Your Ref: OWQC19329
Our Ref: EP/89/18/HH
Please ask for:
Mr Z Denton

19th July 2018

Loft conversion & single storey rear extension
39 Hillview Crescent East Preston

DRW NO 5a SCALE 1/100 (A3)
 PROPOSED ELEVATIONS

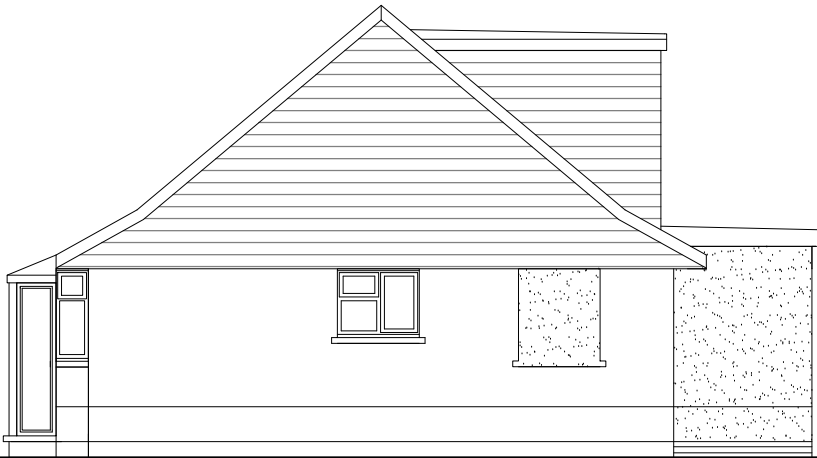
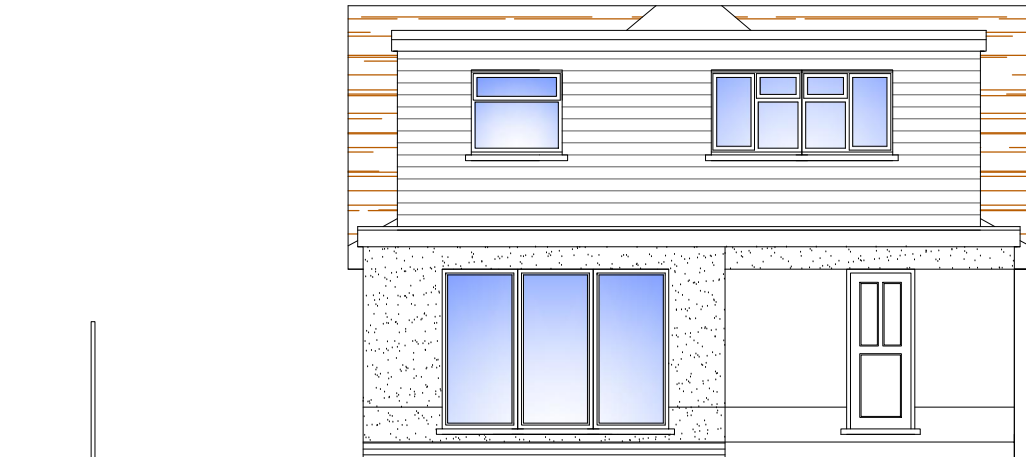
The property, one of the first built in Hillview Crescent, is the only detached bungalow in the road. The proposed extension will result in a very square property, out of keeping with the existing street scene and unlikely to look part of the original design of the house, therefore contrary to Policy 1 of the made East Preston Neighbourhood Plan. Policy 1 of the made East Preston Neighbourhood Plan also states, [extensions] should not be visually intrusive or alter the pattern of the street scene.

Policy 3 of the made East Preston Neighbourhood Plan states A hipped roof should only be changed to a gable end at the rear this proposal is therefore contrary to that policy. Only one nearby property has converted to a side-facing gable end. The proposed roof-works could not be called subservient to the existing property, will be overbearing and would harm the character of the road. These are therefore contrary to Policy 1 of the made East Preston Neighbourhood Plan.

The proposed rooflight in the front elevation does not respect the symmetry of the building as a whole and is therefore also contrary to Policy 1 of the made East Preston Neighbourhood Plan.

The proposal is contrary to Policy 3 of the made East Preston Neighbourhood Plan which states the basic form of the roof is not altered when creating a new room in a roof space.
